Application refs: H02-1006-21, H02-0167-22 and H02-0166-22 – Land to South and West of Harrington Drive, Crowland

Further to the deferral of the above applications and our subsequent meetings with the planning department, we have made further amendments to the schemes and have produced additional drawings as attached. We have noted the changes below, and have included a drawing register and amendment forms for your further consideration.

DRAWING No: 132-BT-01

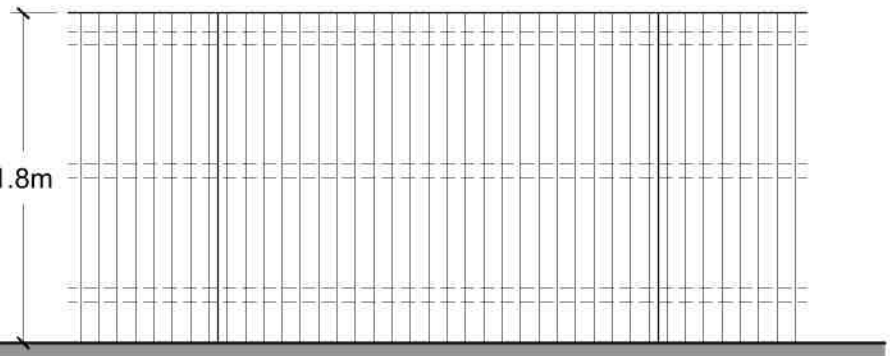
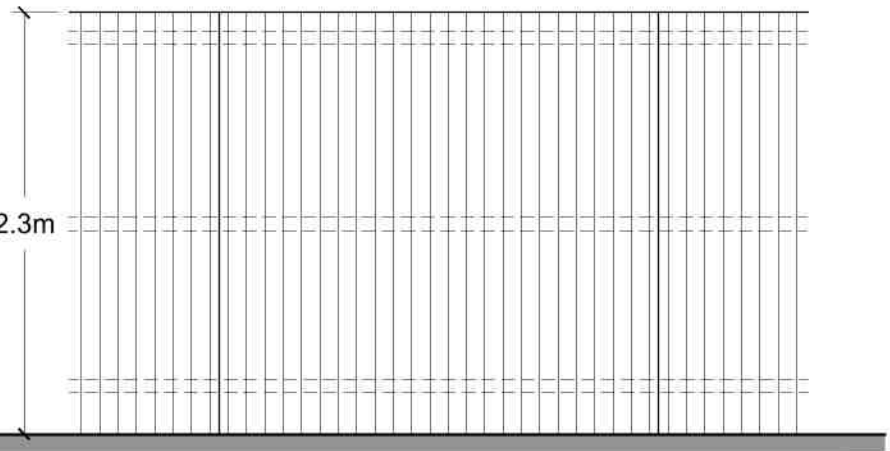
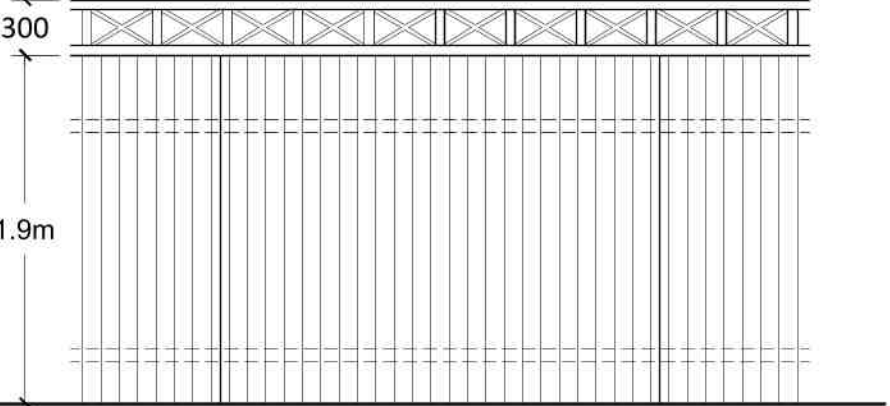
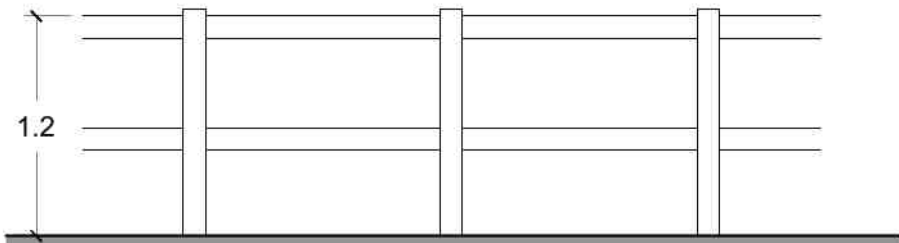
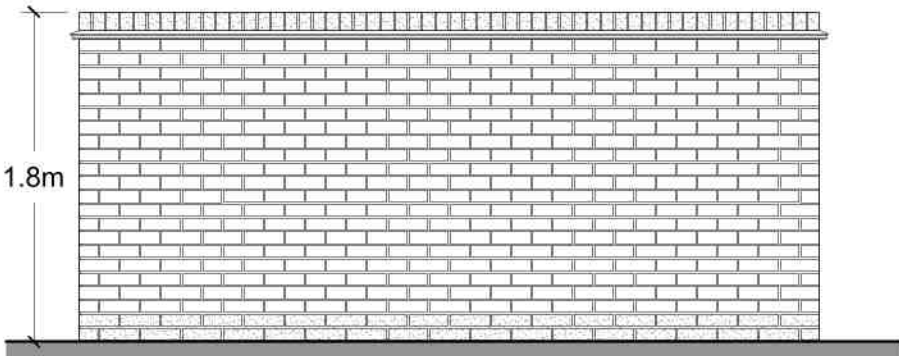
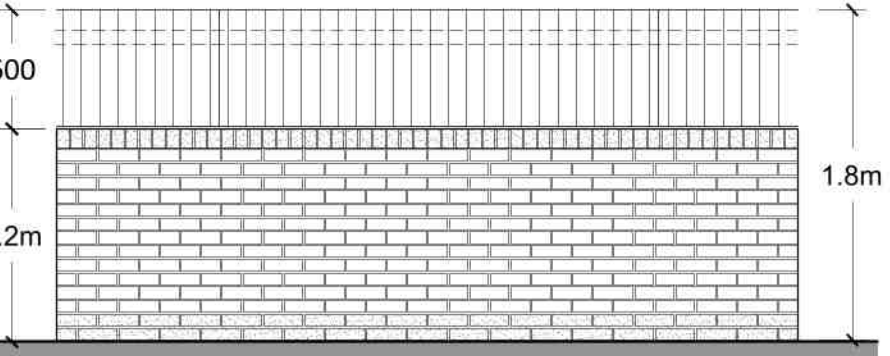
To address concerns with overlooking and as discussed during our meeting on 26th April 2023, we have adjusted affected rear garden patio and fencing levels in line with your comments. See also the note above ref positive drainage at all neighbouring boundaries.

SECTION A-A

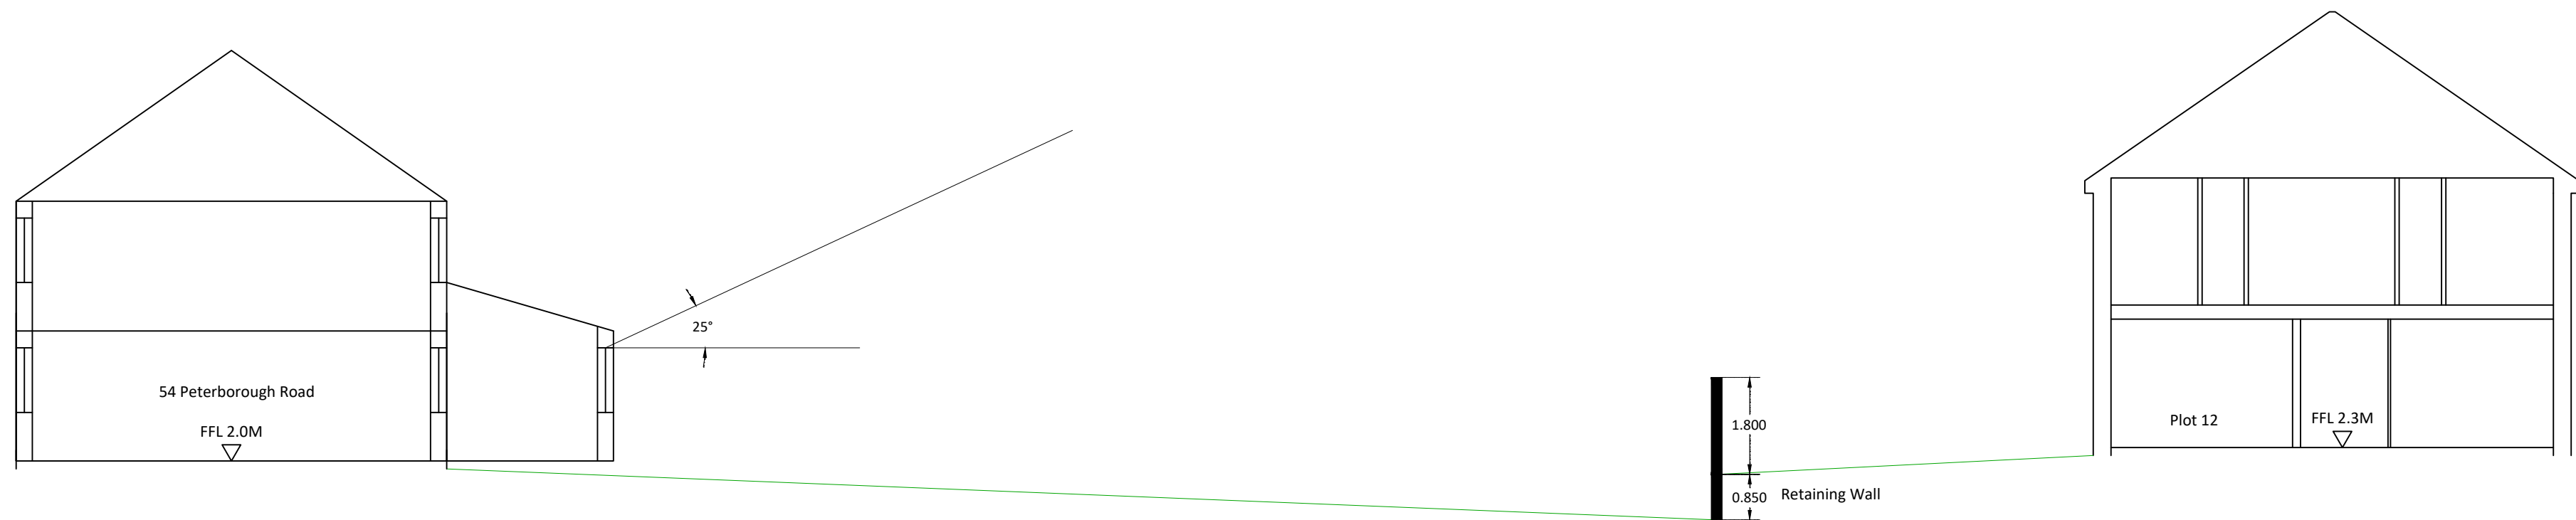
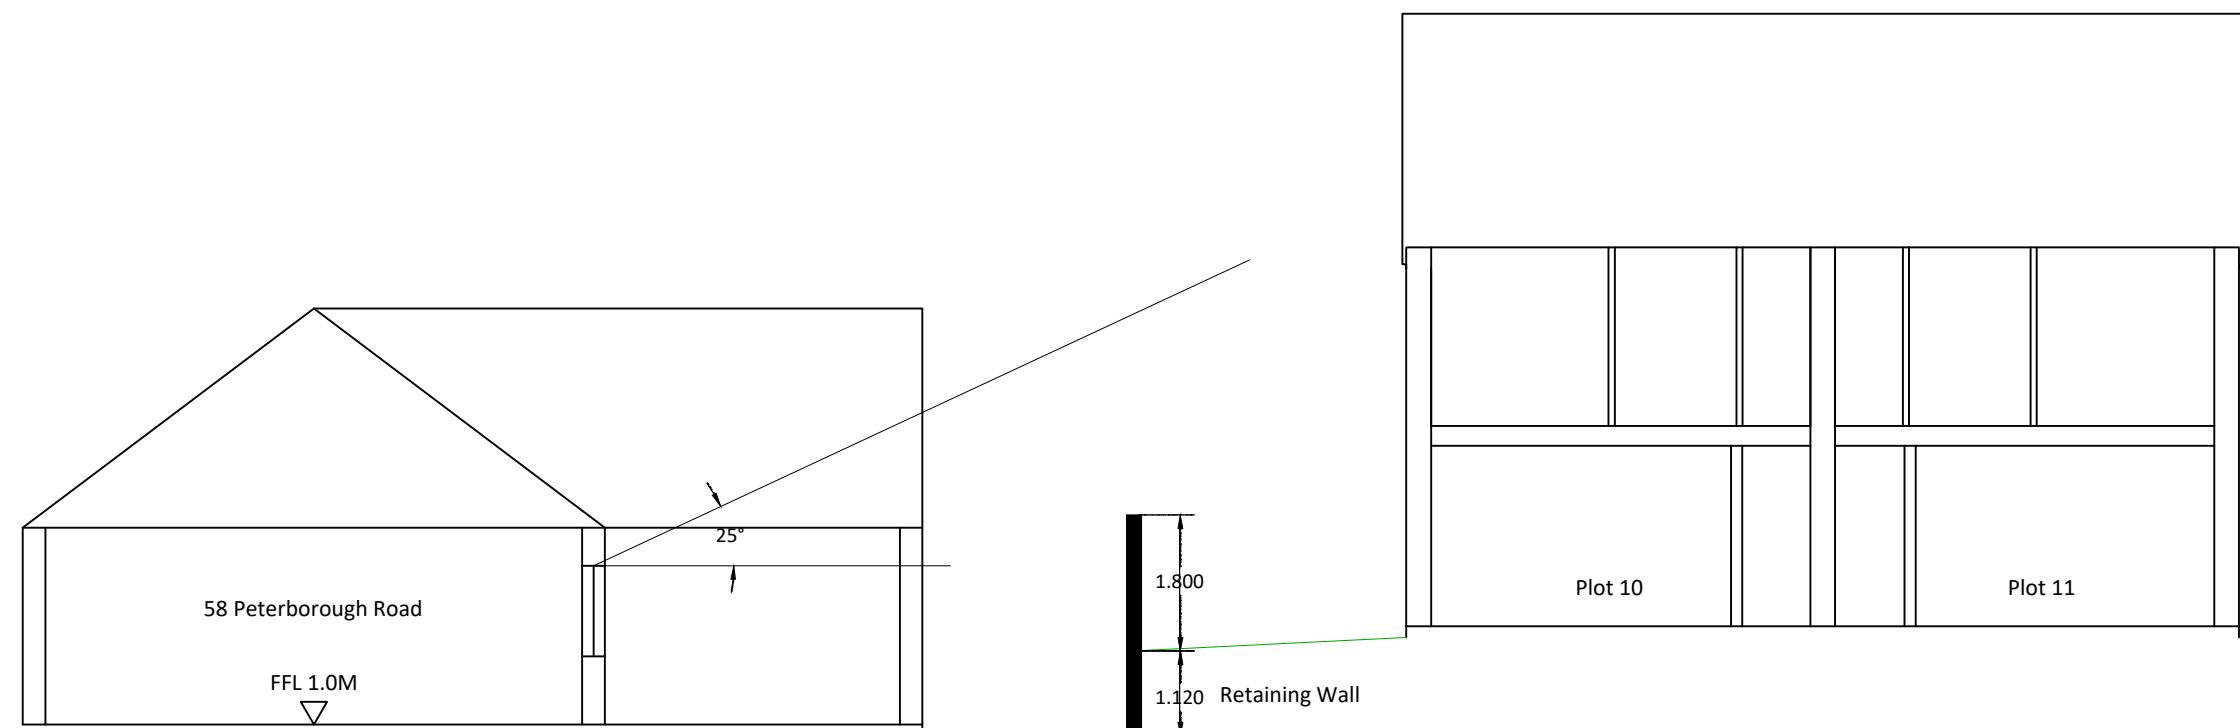
Answering the comment raised at the March 2023 committee, we have lowered the ground level adjacent to 58 Peterborough Road and added a retaining wall to the garden boundary of plot 10. The buffer area between the new plots and the existing bungalow is to be a landscaped area, maintained by a Management Company in perpetuity.

A note has been added to our section drawings to highlight the positive drainage at all neighbour boundaries, as included in our flood risk assessment and drainage strategy.

We have reviewed and improved the section drawings generally to better present the relationship between new and existing plots. We note that new FFL's are dictated by flood risk and are therefore as low as possible in line with The Environment Agency's requirements. With reference to the recent Moulton Chapel refusal, the developer had raised levels in order to avoid introducing a pumped drainage system. This is not the case with our application site, although a pumped drainage solution has not been required in any case due to existing invert levels of sewers and watercourses.
